Planning Officer: Simon Davis

Planning Application Ref: AW/71/18/HH

Location: 36 Kingsway, Aldwick

Description of works: Demolition of existing ground floor extensions to front of property, construction of a single storey rear extension and reworking of existing external hard and soft landscaping. This application affects the character and appearance of the Craigweil House Conservation Area.

| Dwg No.    | 601           |                          |

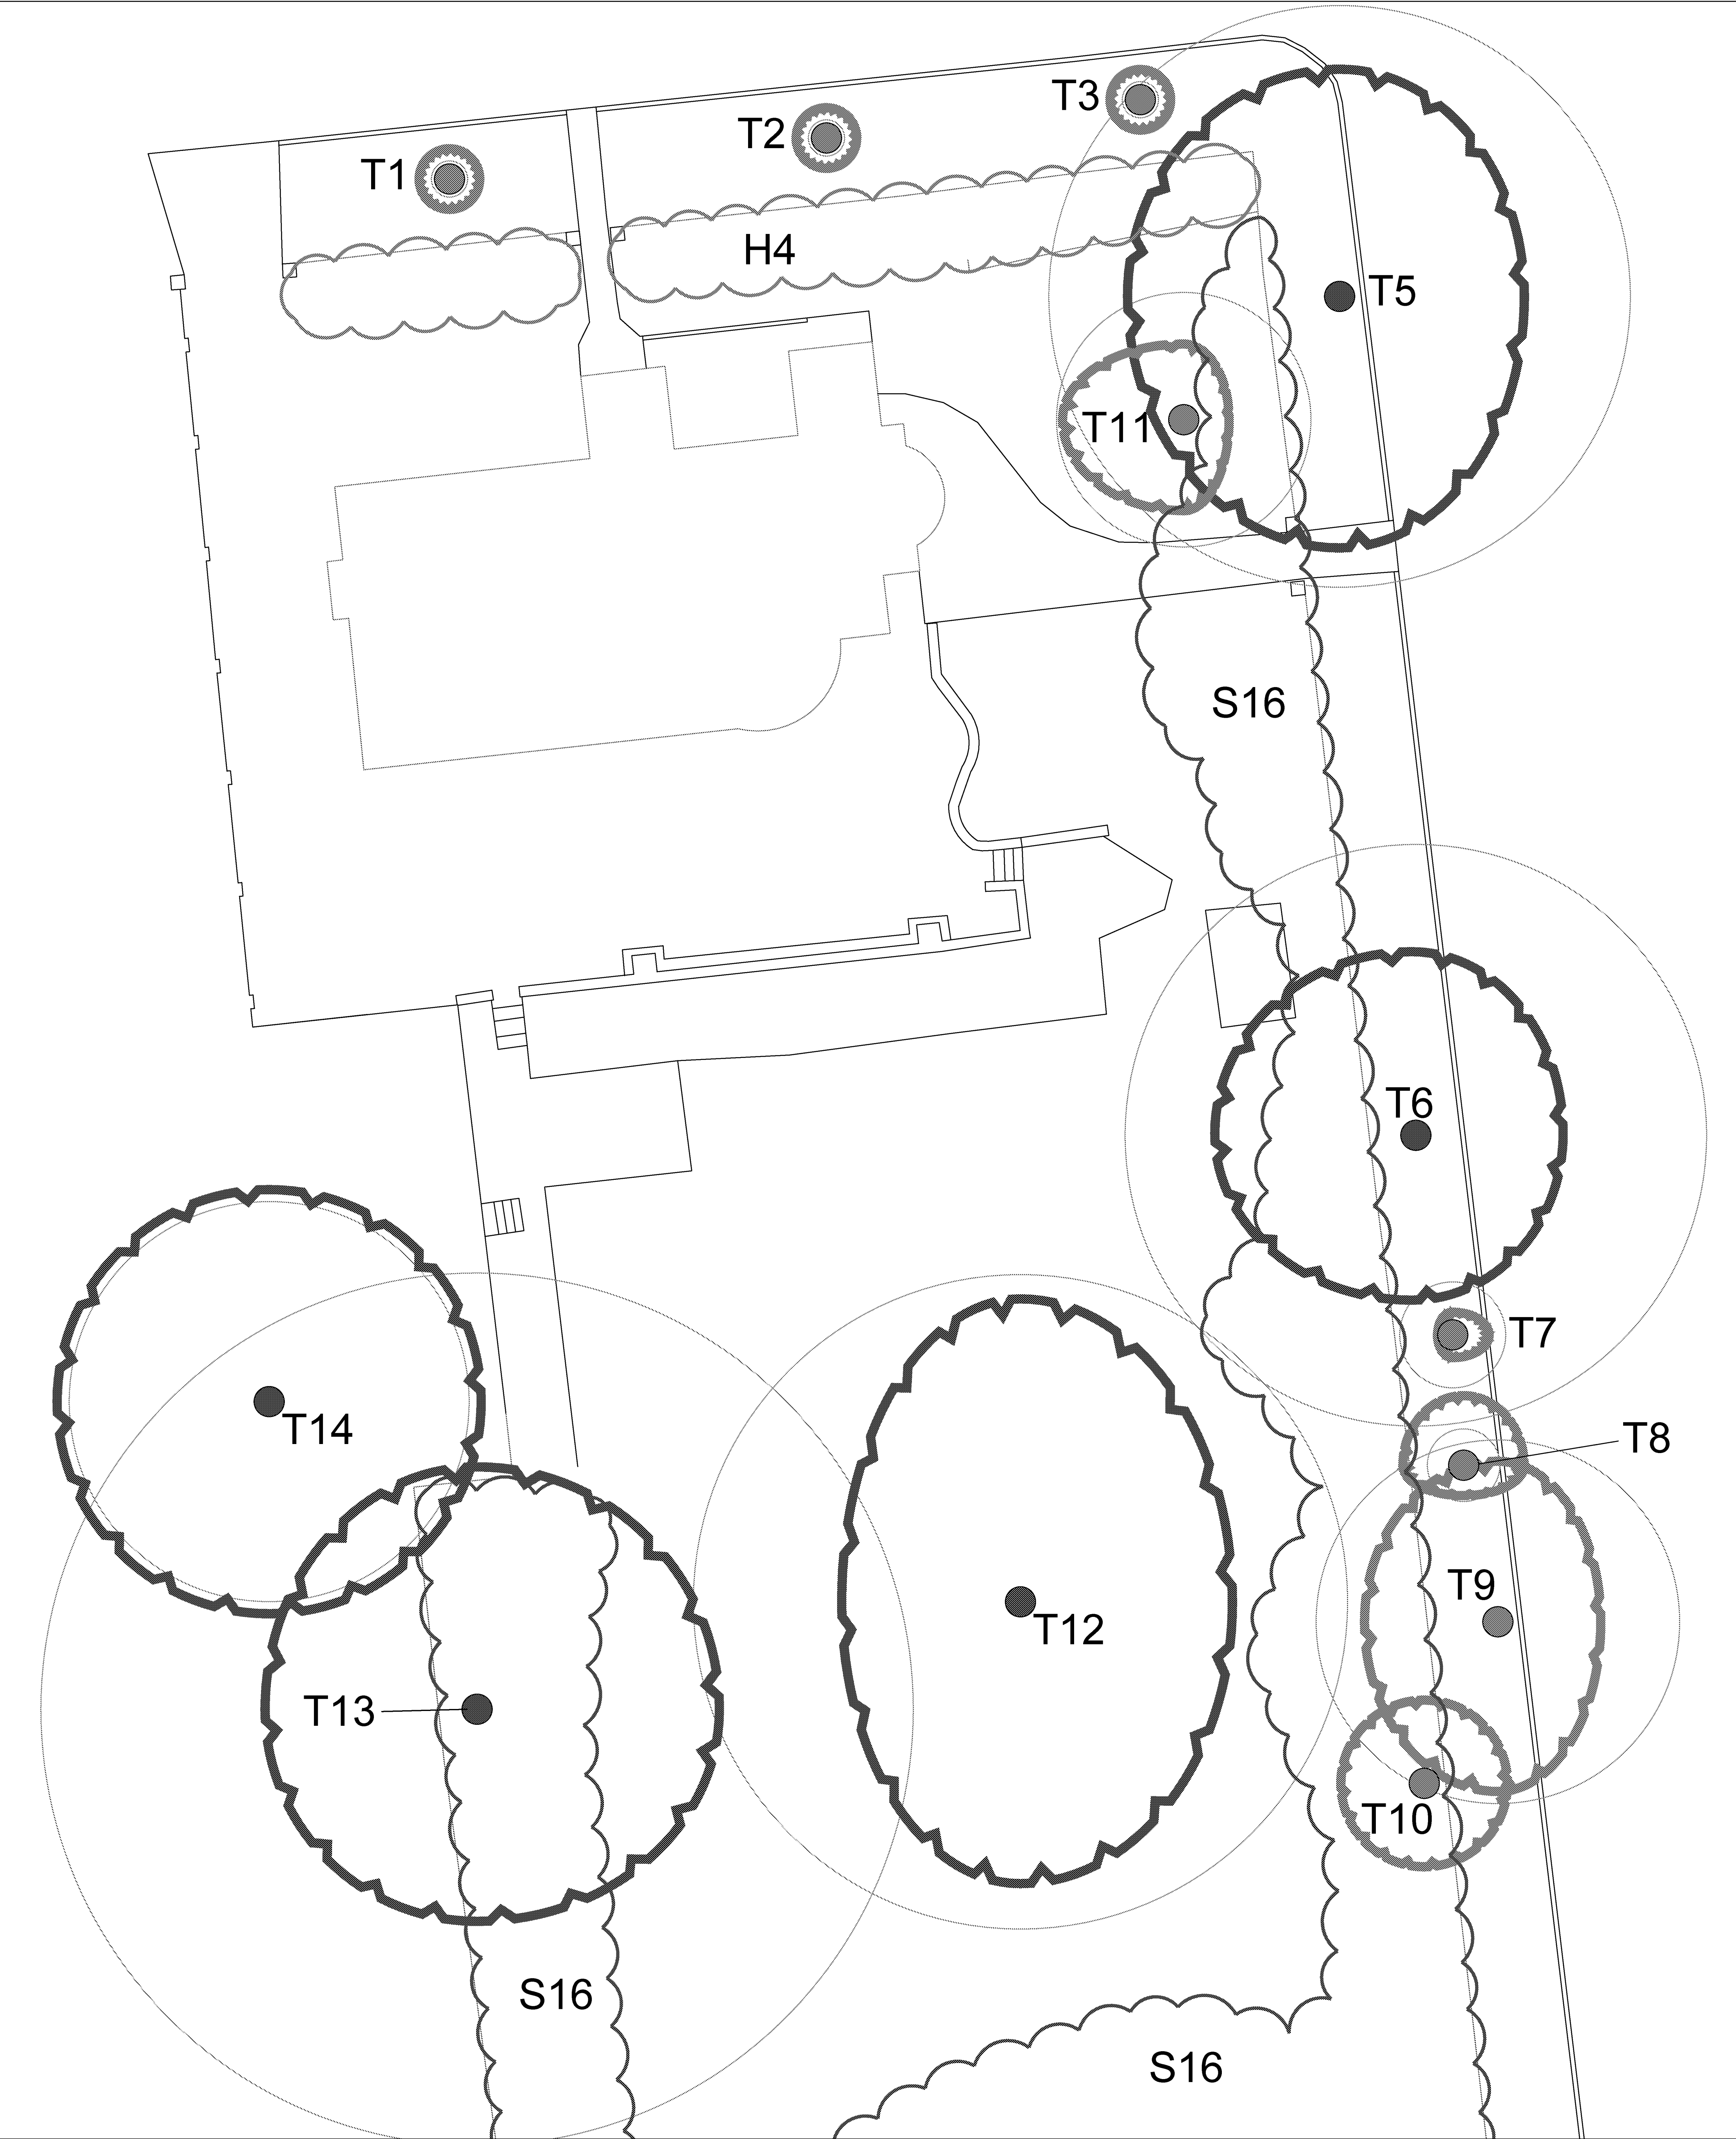
- The Tree Survey data mostly accords with the requirements of BS5837:2012 and I agree with the retention category ratings but there is a significant omission; namely the absence of Root Protection Area (RPA) measurements from the tree survey schedule or elsewhere in the AIA . This element of tree survey data is fundamental to achieve adequate tree protection.

- Of specific interest is T5 (horse chestnut), the subject of an Order (TPO/AW/5/16) and listed as T-1 on the associated Schedule. I measured its stem diameter at 1.5m height to be 895mm and not the recorded 800mm. This may seem a small matter but recognising the ideal RPA is significant in the context of this development proposal - which I return to later in more detail.

- As it stands, I must raise an **OBJECTION** to this application in its current form.
- RPA measurements (radial spread and area) must be added to the tree survey schedule to inform the process. The greater measurement of 895mm has now been recognised and informs the revised RPA (polygon). The agreed RPA broadly follows the indicative plan below but rejects the irregular element over carriageway in Kingsway and compensates with a comparable area of extension to the south -- which I am able to support. The mutually agreeable RPA is detailed on the AIA/AMS drawing no.602 -- Rev B.

Drawing
Arboricultural Impact Assessment,
Arboricultural Method Statement

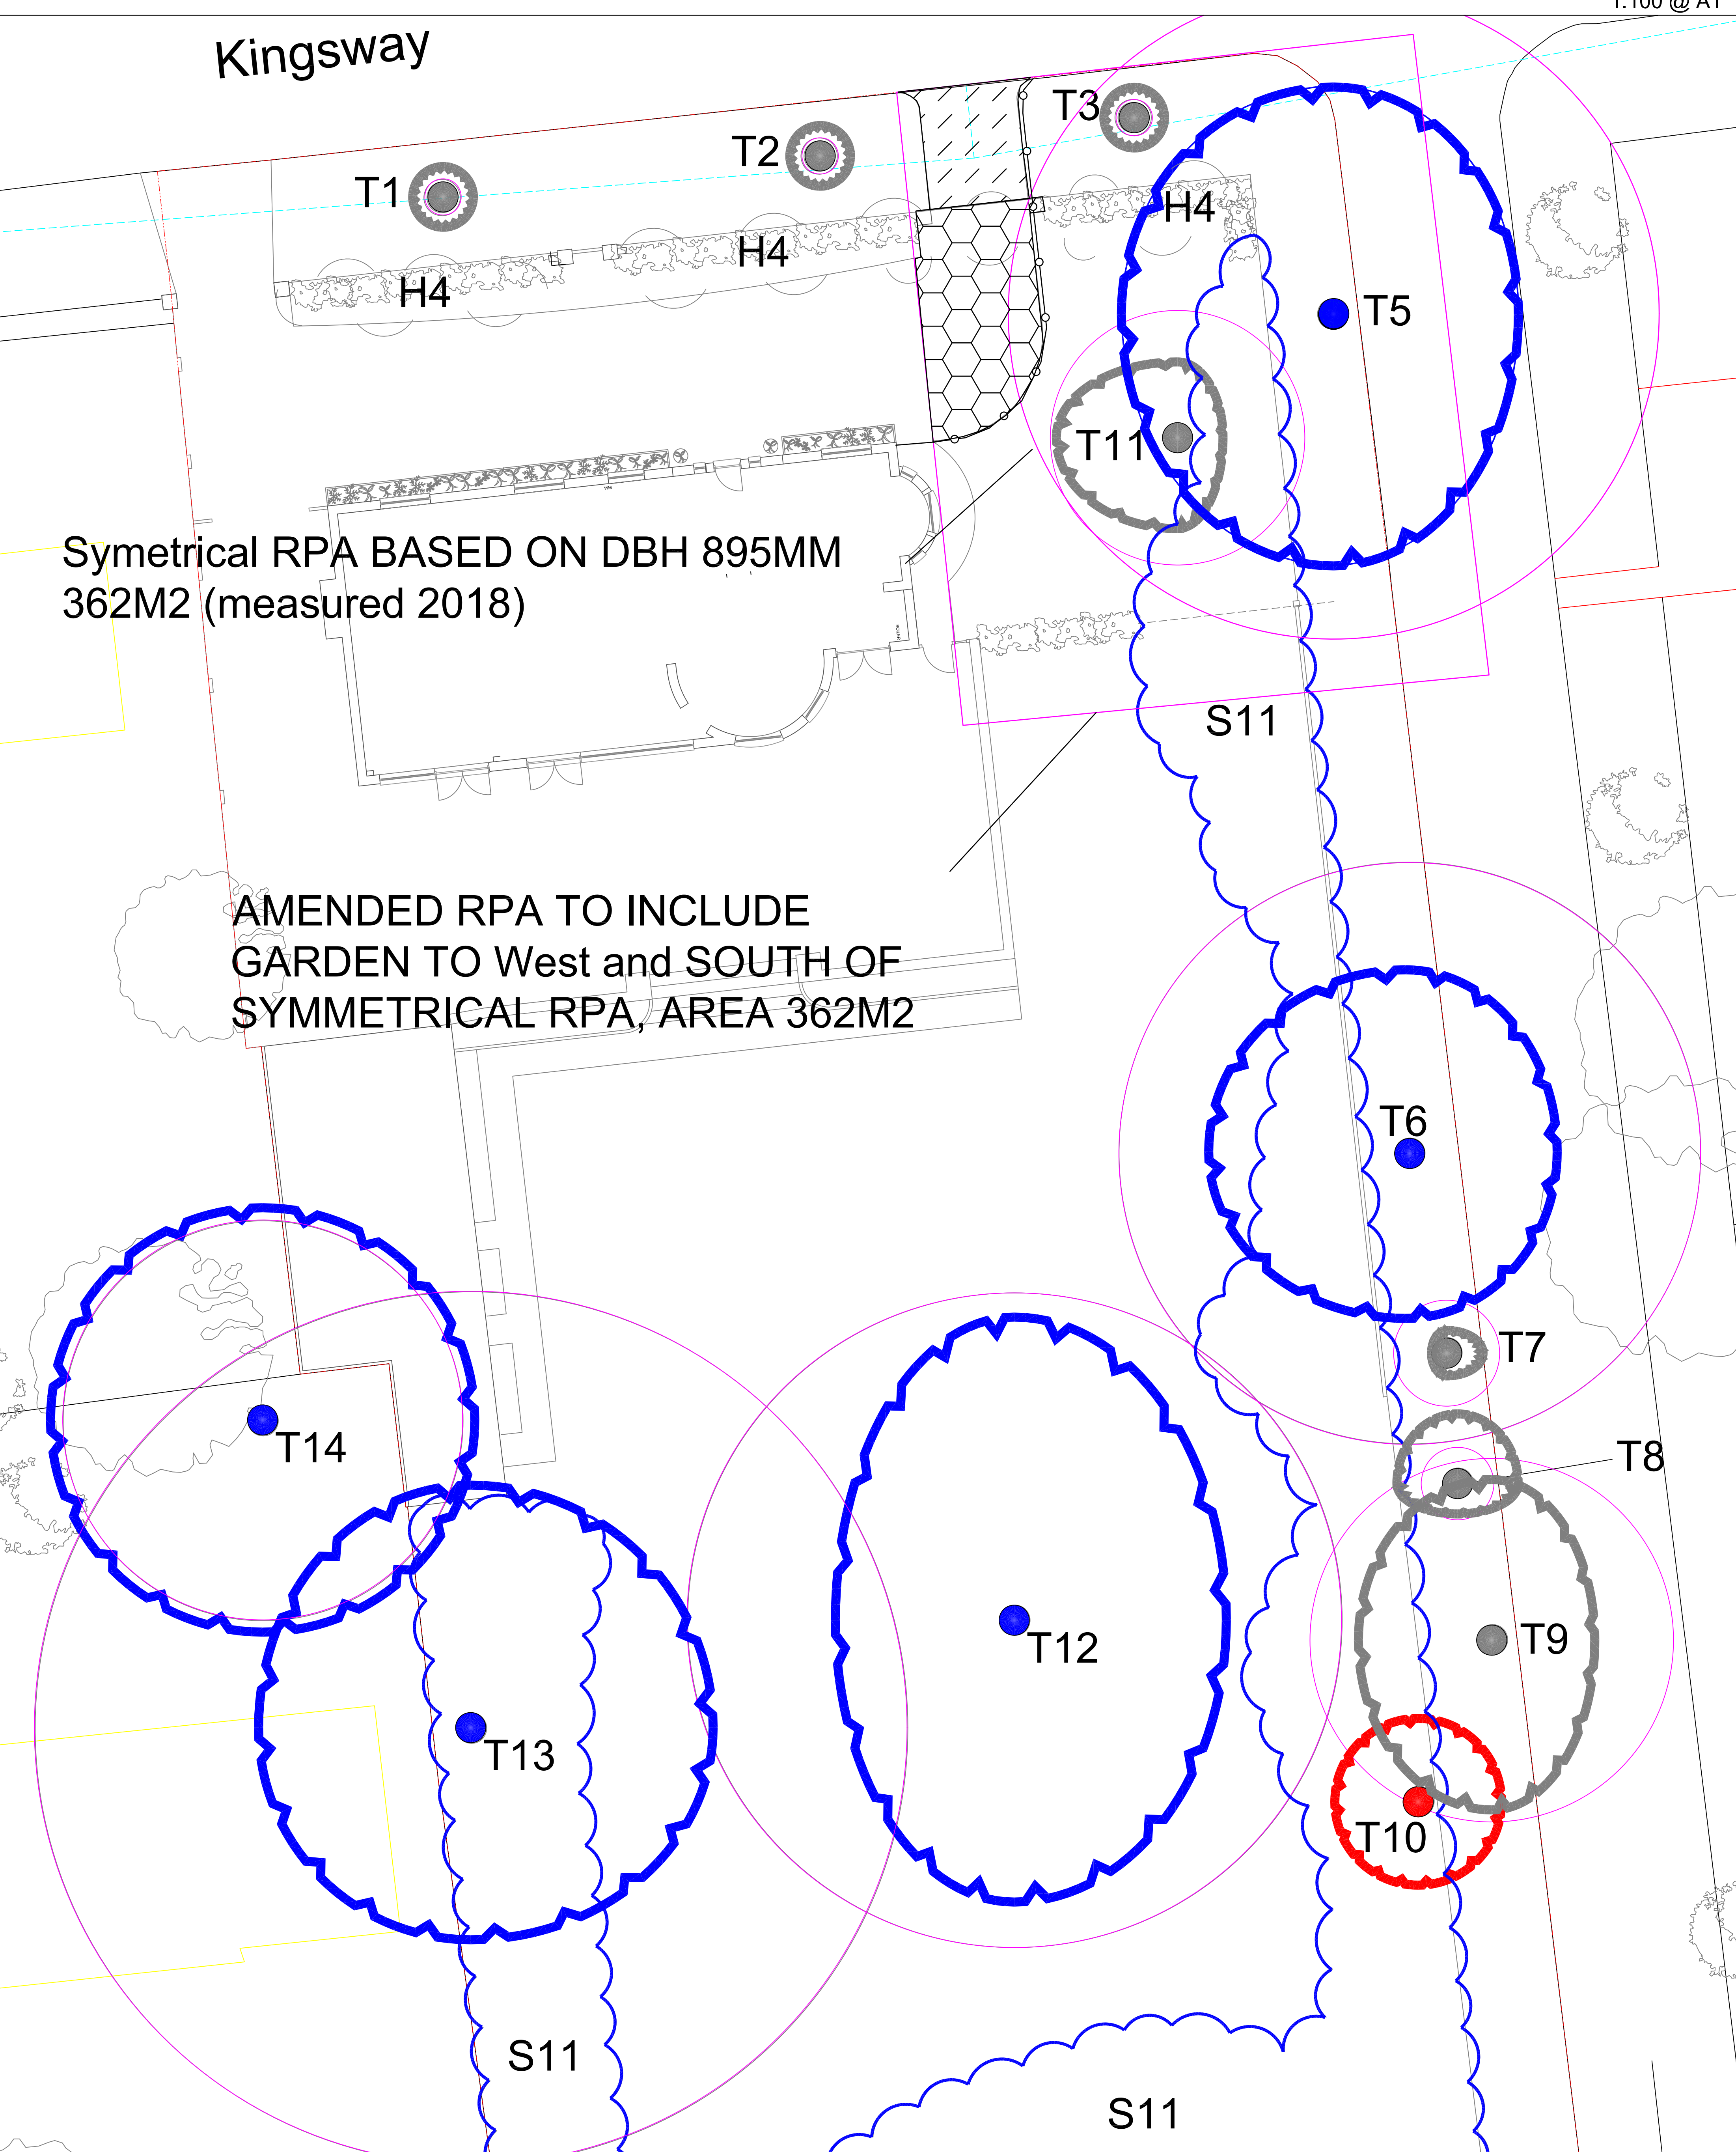
- As it stands, the location of the proposed second driveway access construction is likely to impact severely on the root system of T5 with damaging consequences, such that it could decline rapidly.

- * I would need to see a revised and asymmetric RPA for T5 that adequately compensates for the impediment to root growth as described earlier, before I could consider lending this scheme my full approval. This will require the re-positioning of the second driveway access further west; an alternative 'No-dig' method of construction in the proposed position would demand ground level changes that are unlikely to be acceptable to the applicant. All parties have agreed that ground level changes necessary to accommodate the proposed 'No-dig' solution within the curtilage of the property are achievable and tolerable. As such the original proposed location of the new driveway access is acceptable. I accept the specification as detailed in Cellweb Section -- Tree Root Protection drawing no. GS-CW-BP-75 is adequate for its intended use.

- * I have two outstanding concerns which ought to be easily overcome, but nonetheless should be reflected in a revised AIA/AMS:
 - I request confirmation that the area of 'No-dig' is undisturbed and adequately protected (it lies within the RPA) at the outset and immediately prior to installation of the cellweb construction layer. The ground protection measures necessary to achieve this should be determined by the project arboriculturist, with reference to the recommendations made in SS5837:2012, section 6.2.3.

Tree Survey, Arboricultural Impact Assessment, Arboricultural Method Statement Report, prepared by the Landscape Partnership, March 2018, including Tree Protection Plan dwg.no. AIA/AMS drawing no.602 -- Rev B. and Cellweb Section -- Tree Root Protection dwg no. GS-CW-BP-75.
